SSE Thermal / DWD Property and  
Planning  
Co. FREEPOST KEADBY 3

Thursday 2 September 2021

**Keadby 3 Low Carbon Gas Power Station Project – Stage 2 Consultation in Accordance with s.42  
Waterway: Stainforth & Keadby Canal**

**Figure NTS5: Waterborne Transport Offloading Area**

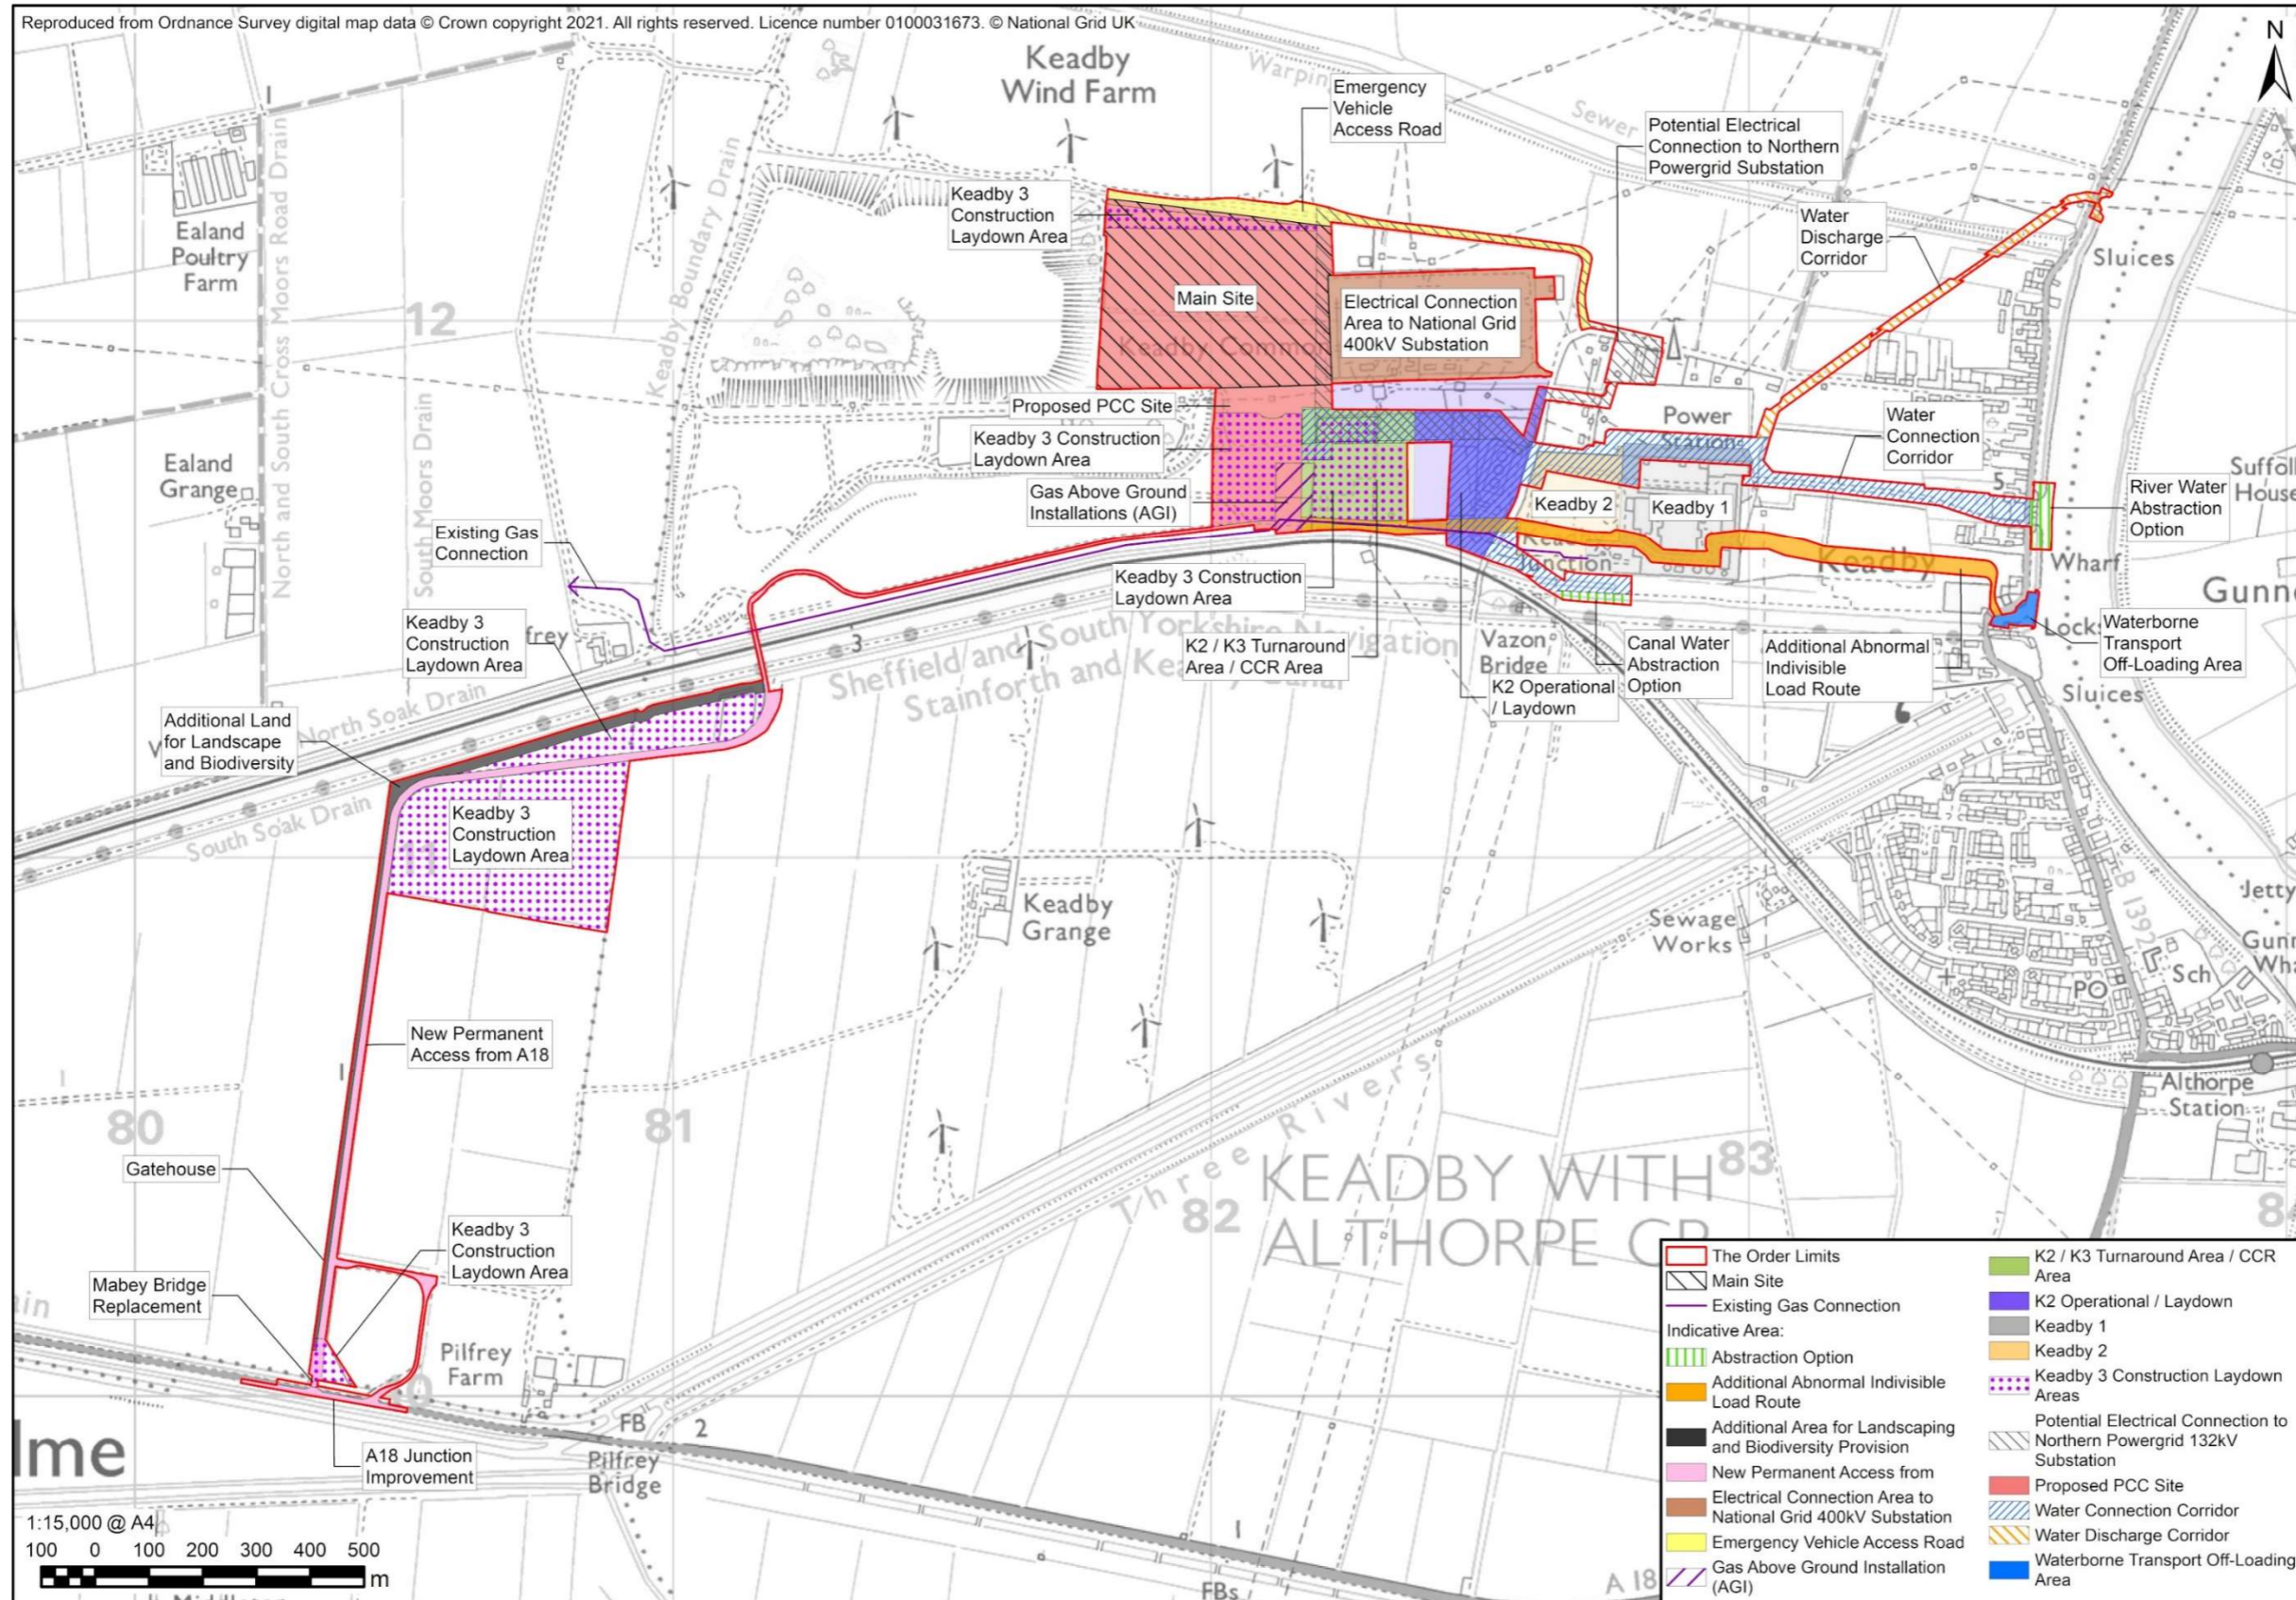
The proximity of the proposed offloading area to the access point for the Stainforth & Keadby canal at Keadby Lock could result in an obstruction to the entrance point of the canal should any oversized vessels be used, which has been observed when larger vessels have used the area in the past. We appreciate that section 10 of the Environment Statement confirms that the deemed Marine Licence (DML) would require consultation with the Trust. However, due to the unscheduled delays that could occur with regards to boat passage, there is a risk that unplanned obstructions to Keadby Lock could occur.

The Trust would welcome the opportunity to discuss the potential for mitigation to limit the potential of any unscheduled obstruction to Keadby Lock. This could involve alterations to the mooring, so that ships move away from the lock when moored up, but not offloading. It is recommended that improvements should be made to the notification system operated by the developers; so that more timely and accurate information and regular updates are received by the Trust and interested boaters could also assist in managing any obstruction to boat passage.

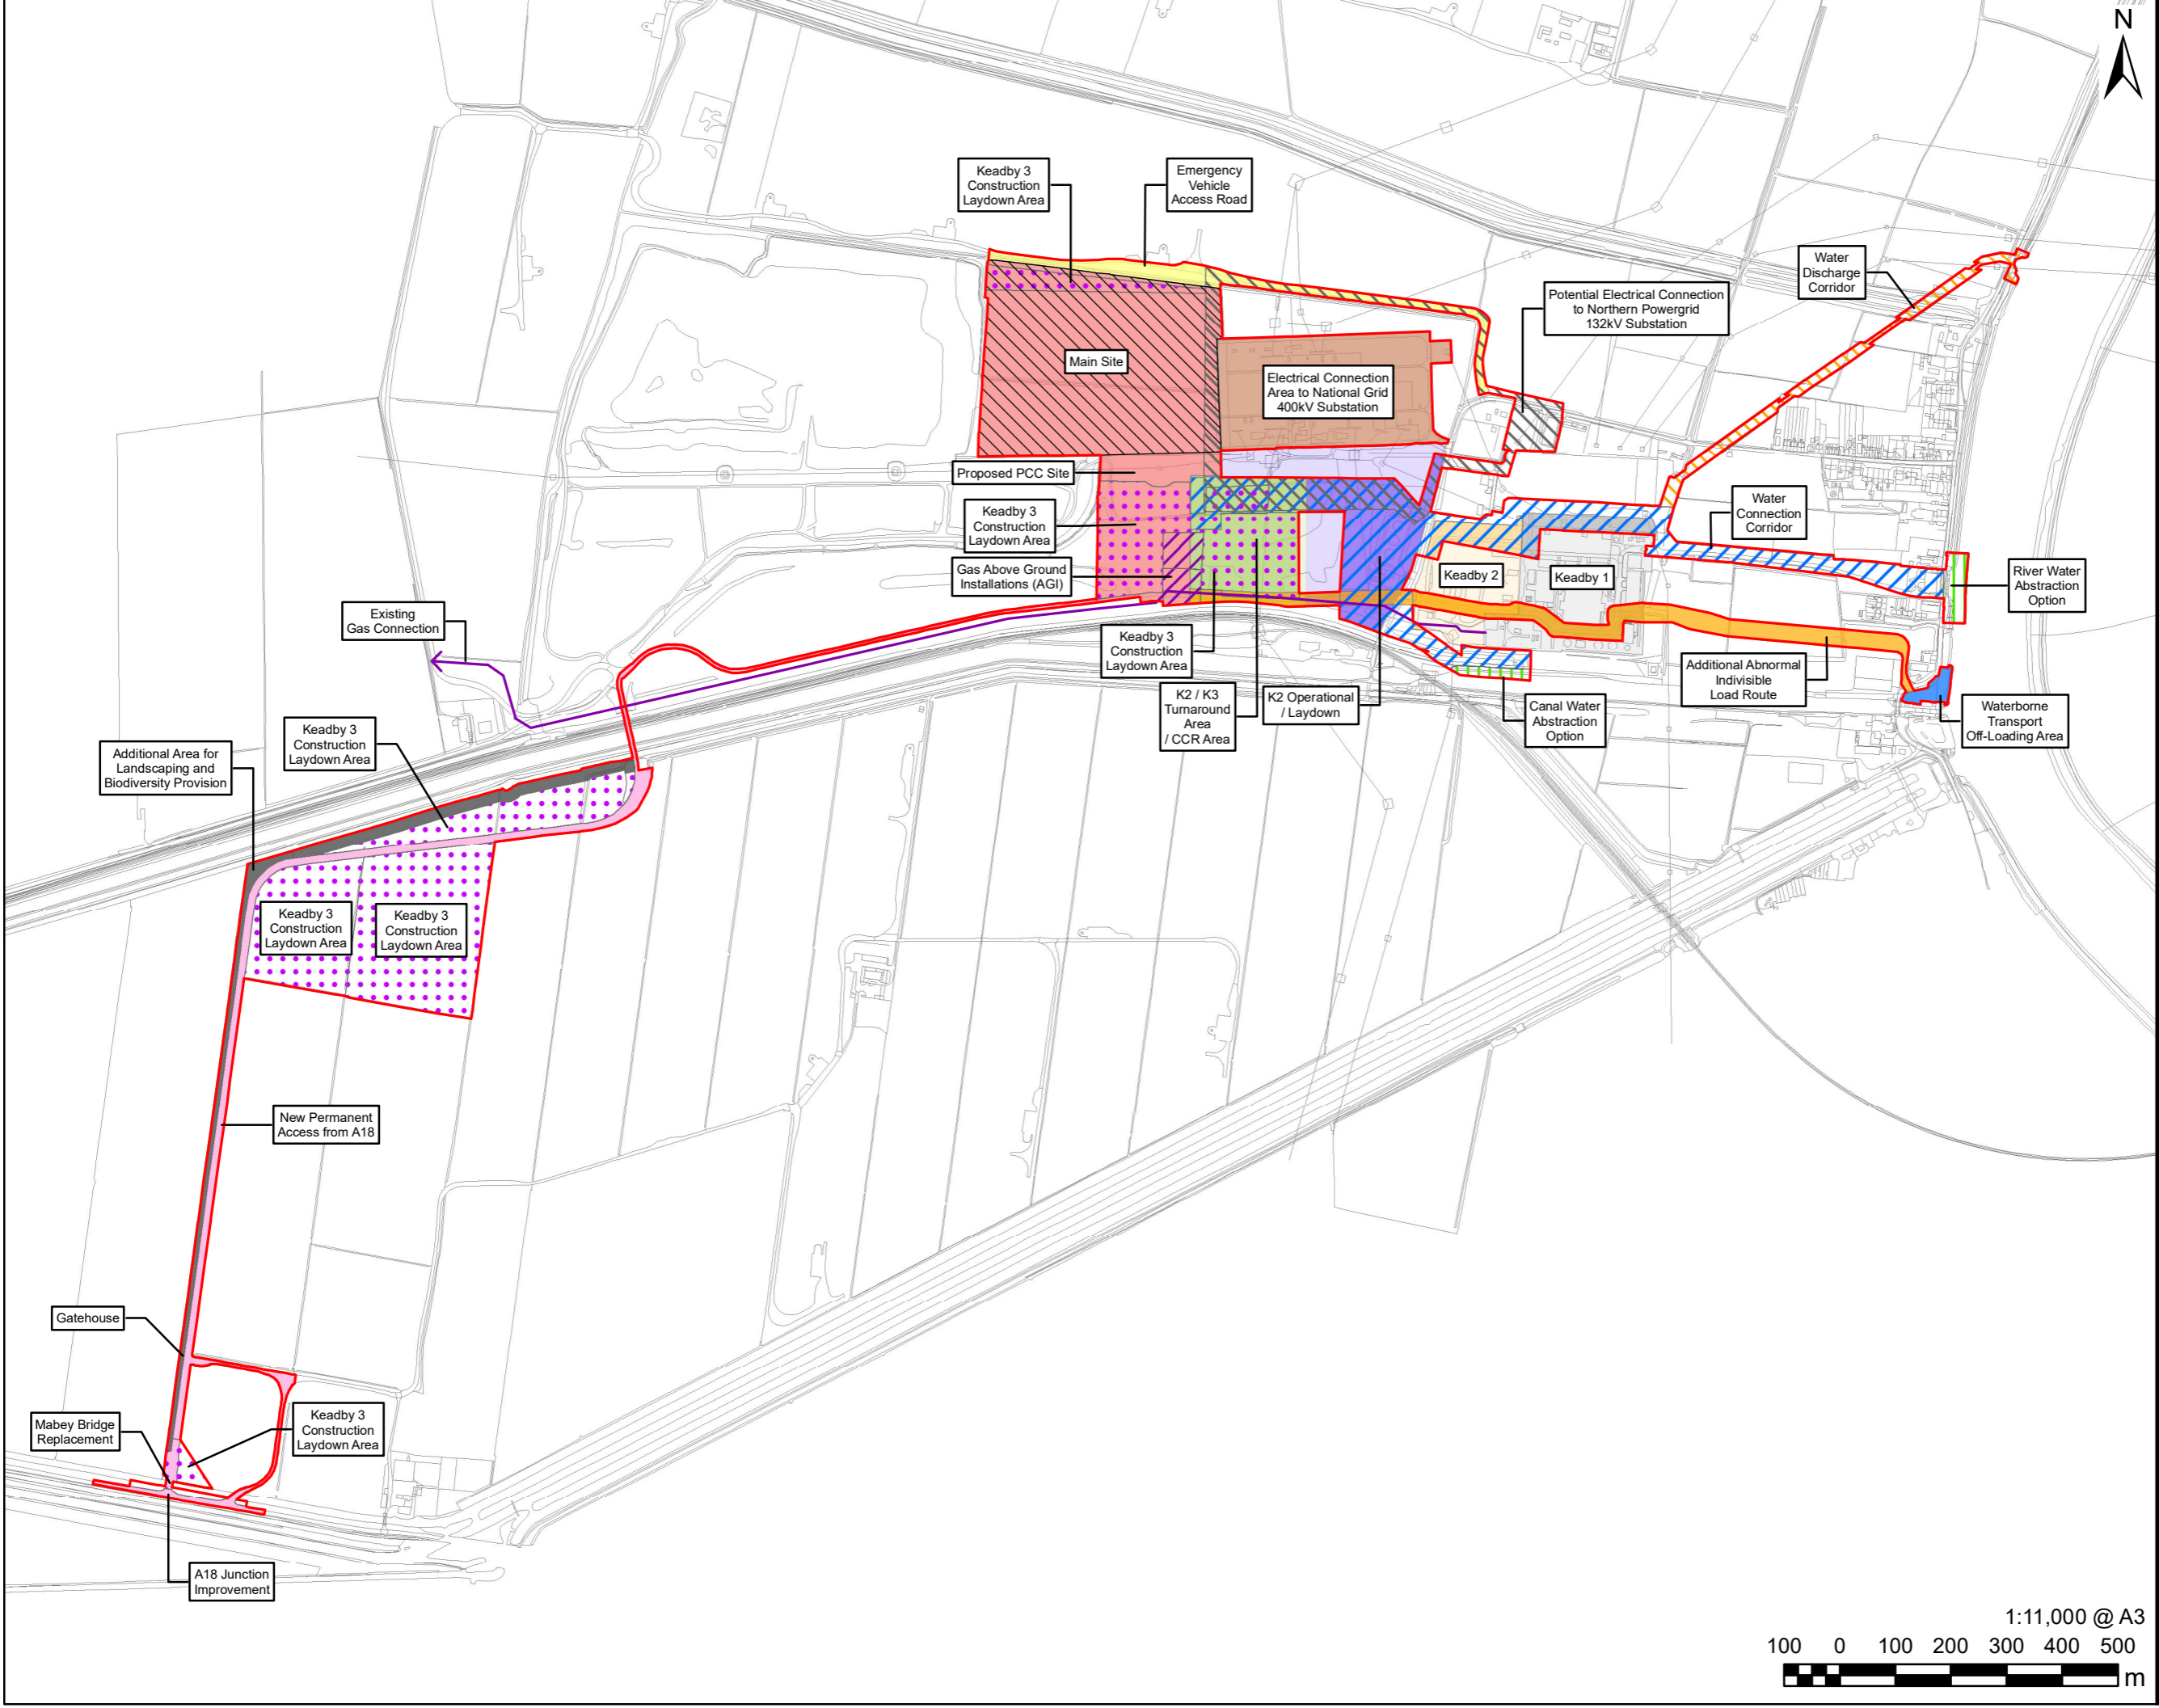
The incorporation of an additional abstraction point from the Stainforth & Keadby Canal is proposed as part of Work No. 4A.

The proposed abstraction apparatus has the potential to impact upon navigational safety, ecology and the outward character and appearance of the canal corridor. We therefore request that the exact details of abstraction, notably with regards to the angle of flow, are made a condition of any DCO so that the full impact can be assessed by the Trust, and that the Trust are included as a consultee within any such wording. We note that schedule 2 (4) requires the submission of details of Work No 4A, which could include this information, but does not include the Trust as prescribed consultee. We therefore respectfully request that the Trust is included as a prescribed consultee.

We wish to highlight that works within several Work Areas have the potential to impact the Trust's assets. Whilst paragraph 18 refers to Work Nos 4A, 8A and 10B, we request that this should be expanded to include Work Nos 9A, 9B and 11A, which lie in proximity to the canal and involve works or processes that could potentially impact the canal.
